Comments on the Applicant's D2 Submissions

This document sets out the comments by Cambridgeshire County Council (**CCC**) on the Applicant's Deadline 2 (**D2**) submissions. The table below provides the relevant paragraph or reference numbers.

Comments on the Applicant's D2 Submissions	1
Applicant Response to Local Impact Reports [REP2-043]	2
ES Vol 1 Chapter 15: Climate Change [REP2-013]	5
ES Vol 2 Technical Appendices: Appendix 6-9: Site D Trial Trench Evaluation Final Report [REP2-018]	5
Outline Archaeological Mitigation Strategy [REP2-035]	6
Outline Landscape and Ecological Management Plan [REP2-033]	6
Natural England Letter of No Impediment: Great Crested Newts [REP2-047]	8

Figure 54: Trench 935 Excavated Features

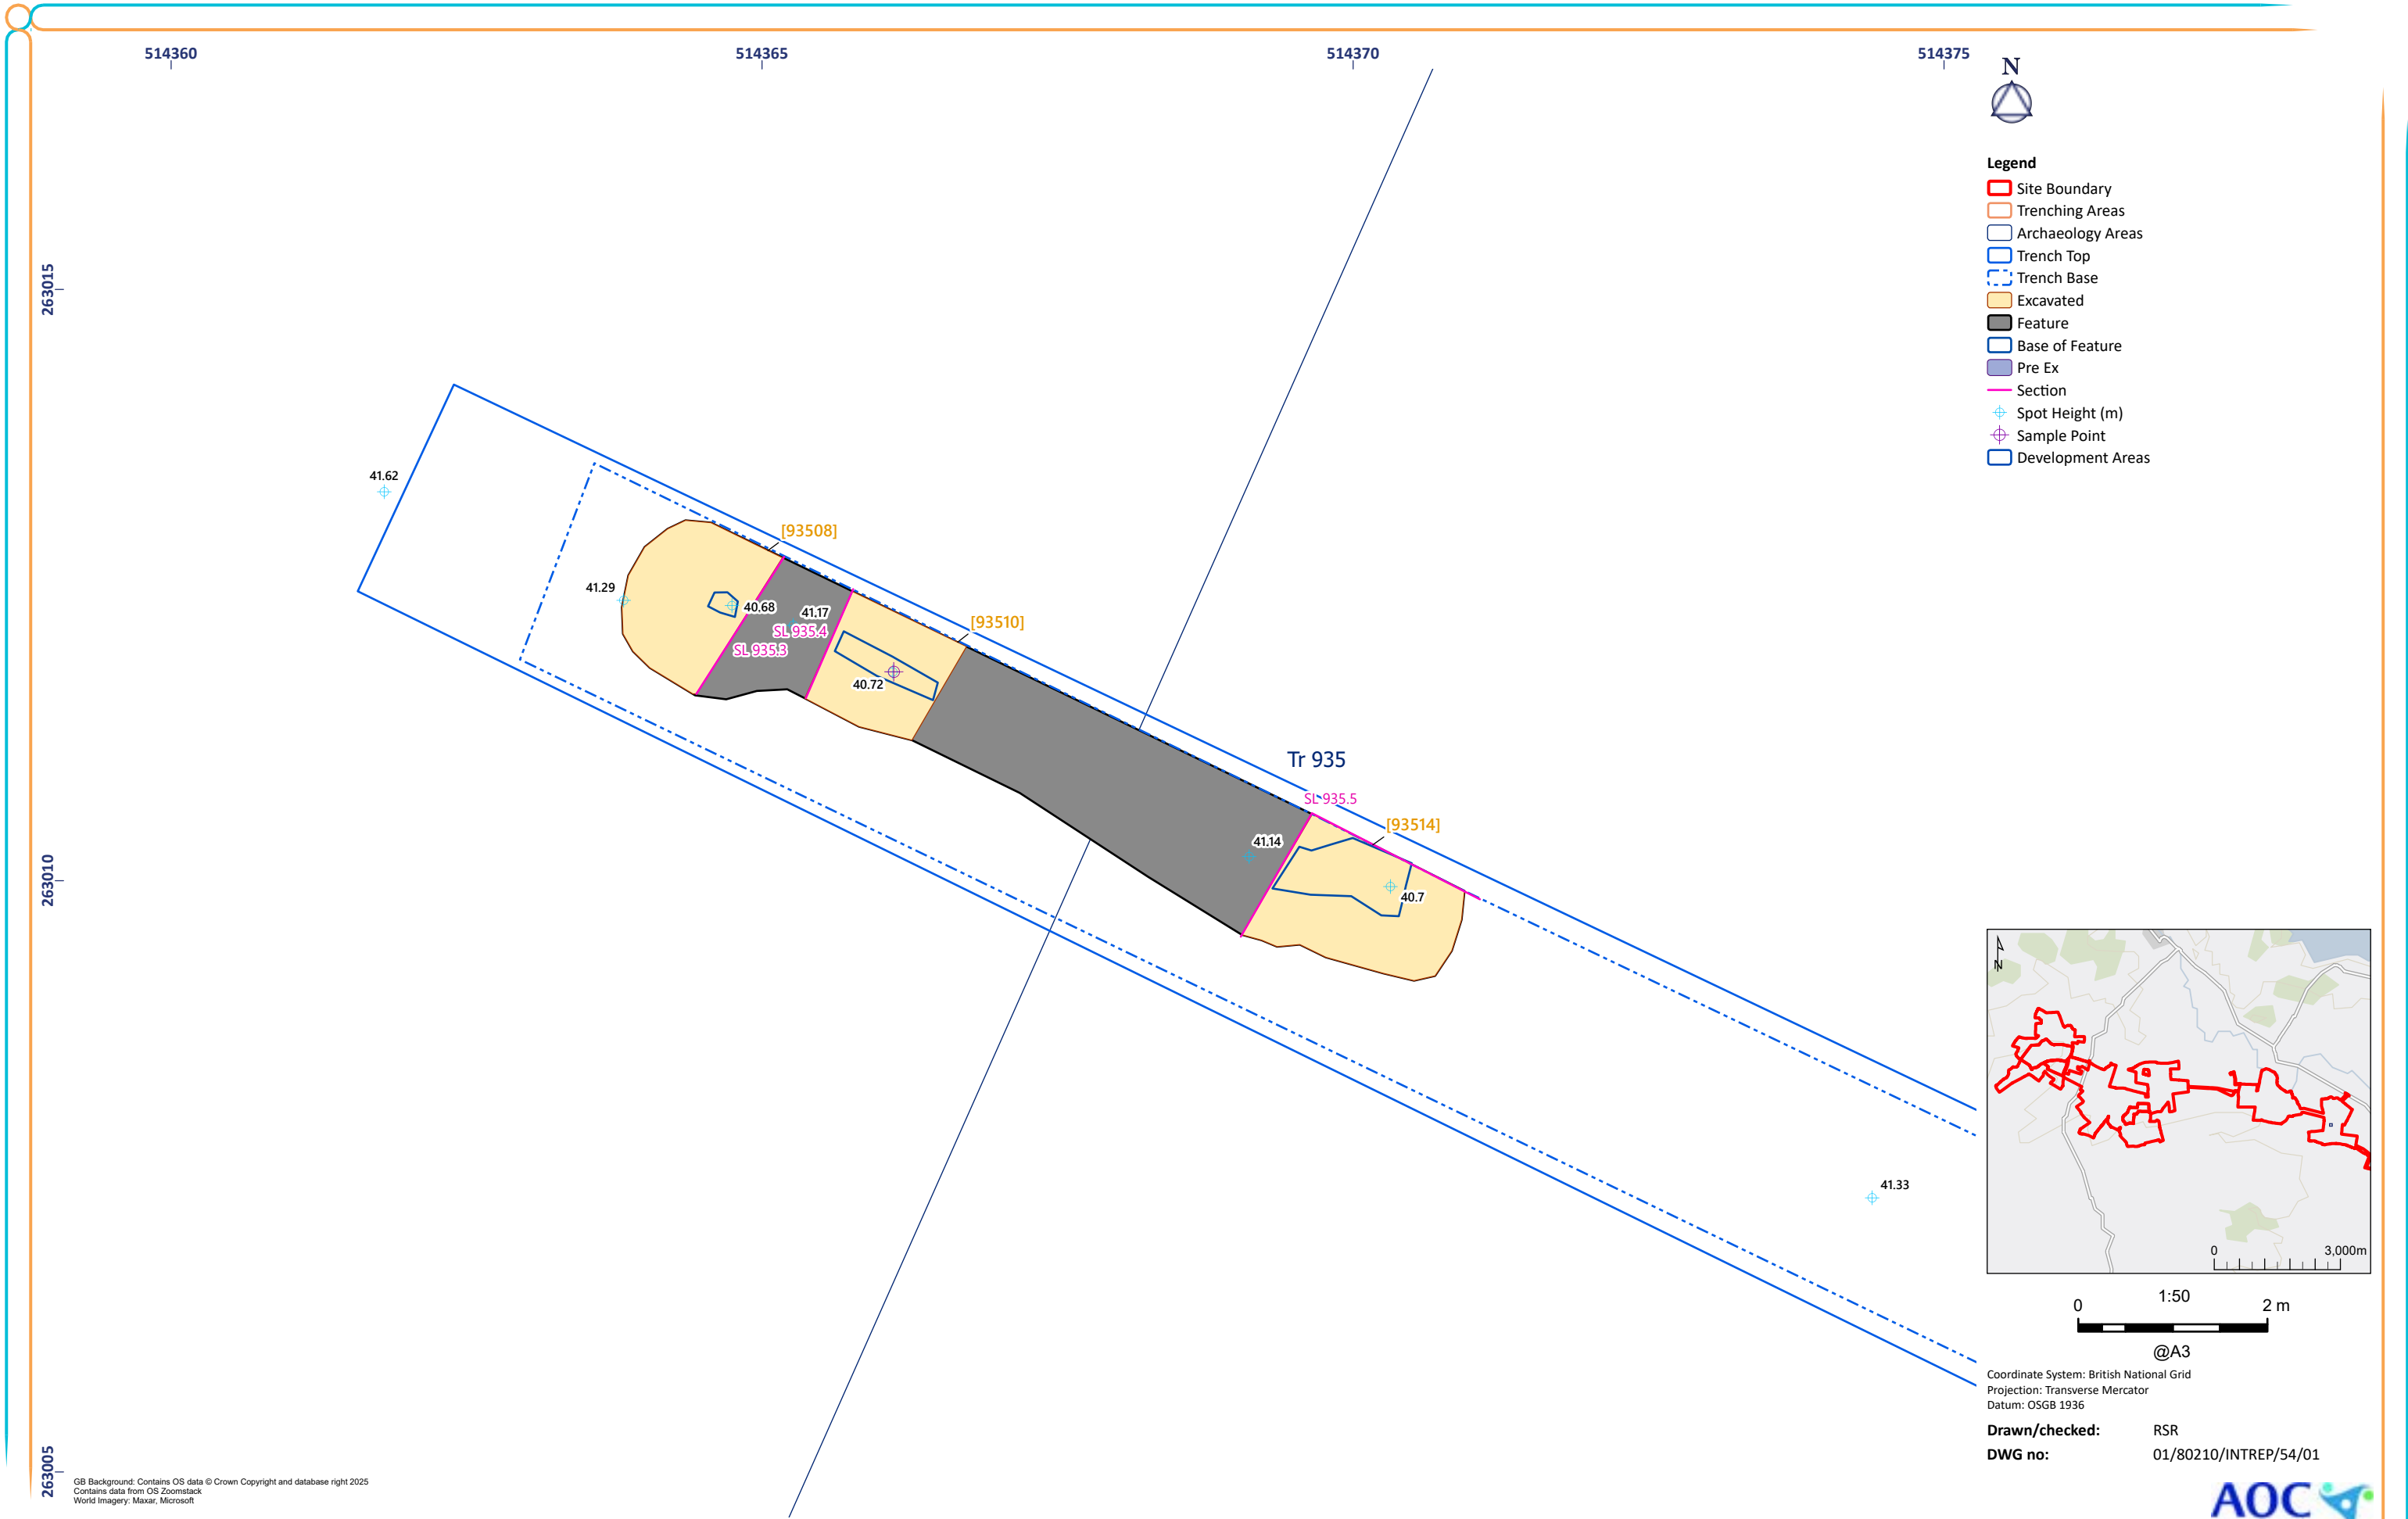
3.1	The wording should be changed to Area D, not Area B.
	6.64	The results for Trench 935 need further consideration of why the geophysical anomalies did not show up, especially as a feature was found in section.
